# Loreto Normanhurst School

## Environmental Impact Statement Traffic Peer Review

A Supplementary RtS traffic report has been prepared by TTW (dated 7 May 2021). This technical note summarises our review of TTW's traffic report and the Supplementary RtS from Hornsby Shire Council, Transport for NSW and Greys Consulting's peer review (dated 15 March 2021).

**Figure 6.1: Traffic Movements through Existing PUDO Facility**

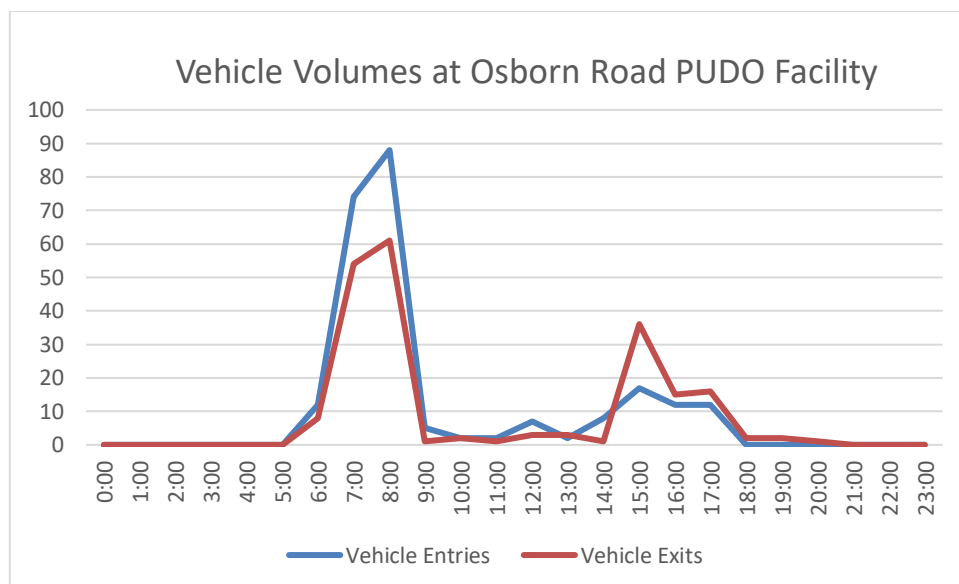
Issue Raised	Applicant’s Response	Bitzios’ Response
<b>Queuing Analysis</b>		
Queuing length resulting from pickup/drop off facilities should be included in the volumes of Figure 6.1. Determine if there will be any extensive queues line up during sharp peak times (8am-8:20am and 3:15pm-3:30pm). Results should also relate to spill back into Osborn Road The statement “It was observed on site that some queuing can occur during peak periods as a result of the above geometrical constraints and driver behaviour.” in s6.1.2 needs to be quantified.	<p>The volumes in Figure 6.1 of the original Traffic Report dated 15 January 2020 included in the first response to submission provide movements into and out of the existing pick up and drop off facility and have been used to project future demands of the pick-up and drop-off facility. The proposed pick up and drop off facility will provide through lanes to enable recirculation and will be marshalled to prevent queuing onto adjacent streets.</p> <p>As stated in the current Traffic RtS Report (Appendix A), the existing pick up and drop off facility is insufficient in terms of length for drop off and has existing geometry that discourages recirculation by drivers. For this reason the relocation of this drop off is proposed as part of the Stage 1 works. Refer to <b>Appendix A</b> for proposed queuing locations. As part of the ELC approval process, drone surveys were undertaken in September 2019 of the intersections of Osborn Road and Mount Pleasant Avenue with Pennant Hills Road to review queue lengths within Osborn Road. These surveys identified a 9 vehicle queue, refer to Appendix B in the Traffic RtS Report for a copy of this report.</p>	<p>This issue has been adequately addressed.</p>
